Your Ref: OWQC18192
Our Ref: BE/40/18/PL
Please ask for:
Mr D Easton

14th May 2018

New access from New Barn Lane to Land West of New Barn Lane & relocation of 5 No. existing parking spaces.

Land West of New Barn Lane Bersted

Proposed Access to New Barn Lane

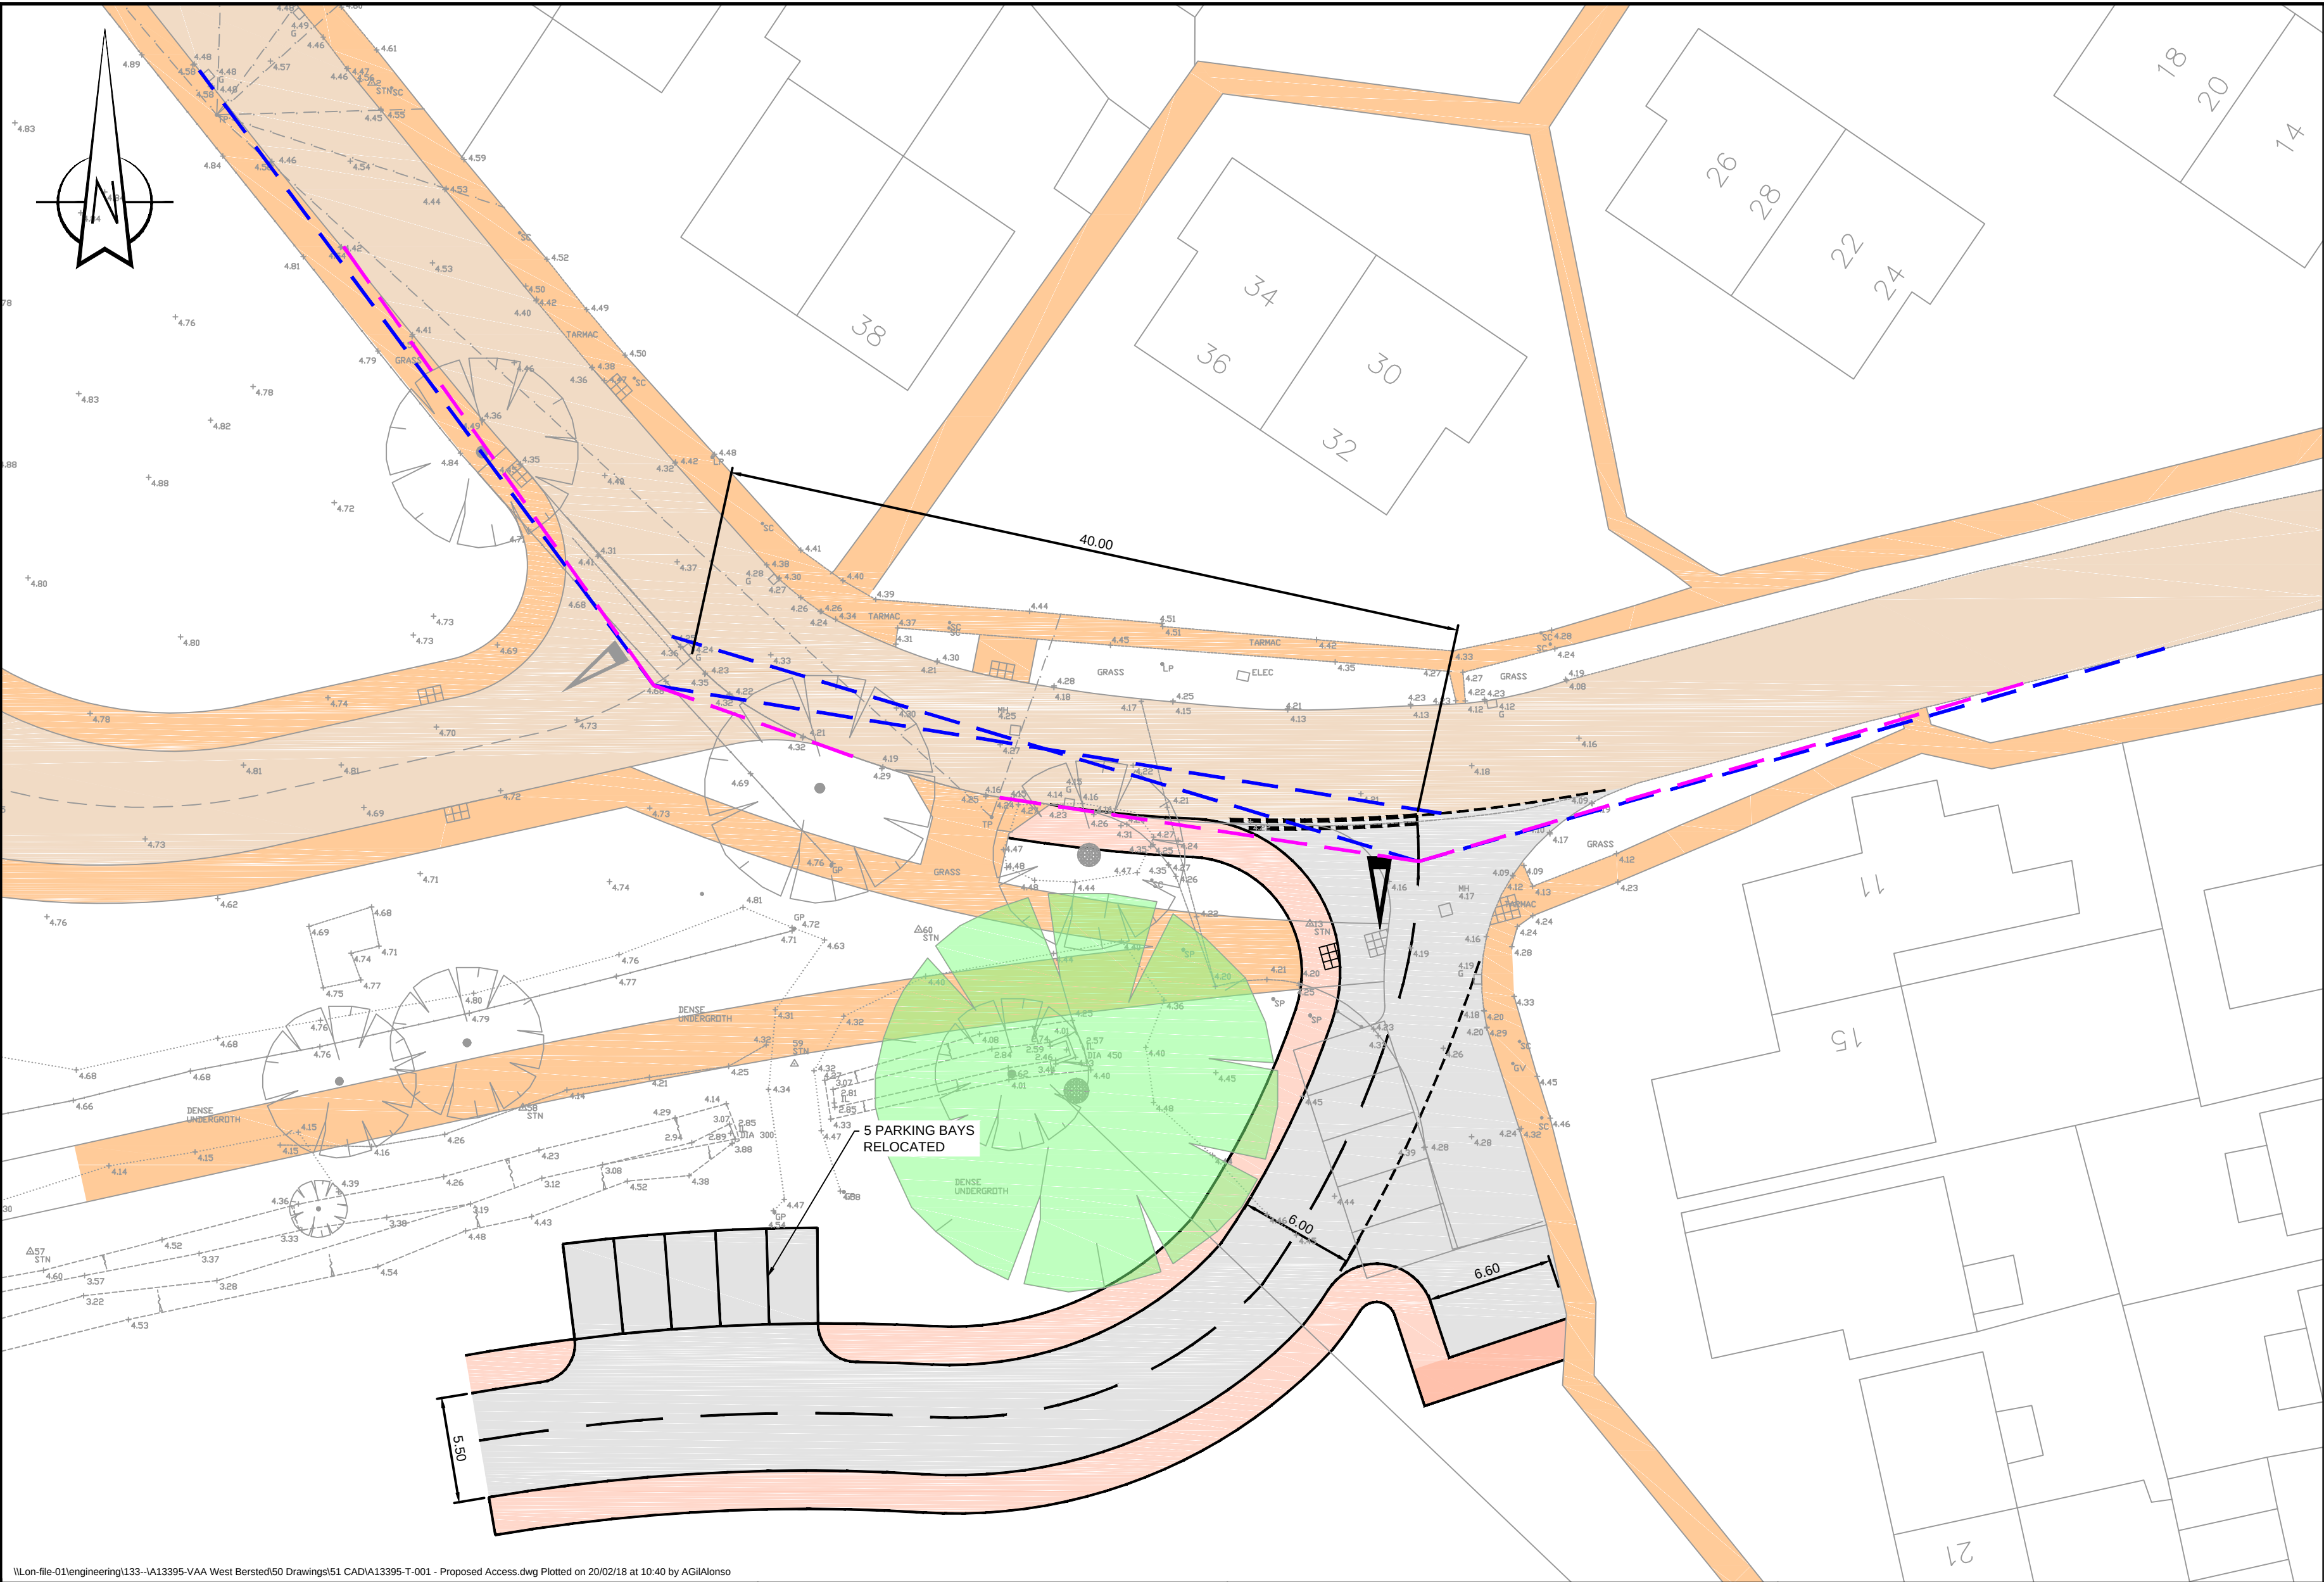
1) *The proposed new entrance is unneighbourly to the bungalows (11 - 21 New Barn lane) directly in front of the access*

2) *Loss of parking for those bungalows 19 - 21 New Barn lane, removal of the 5 spaces to a new location inside the development does not guarantee that they will get use of them and is contrary to Bersted Neighbourhood Development plan policy HDQ8 for accessible car parking.*

3) *Highway safety and traffic, as bungalows 11 to 17 have driveways that are in direct line with the proposed access which may cause safety issues.*
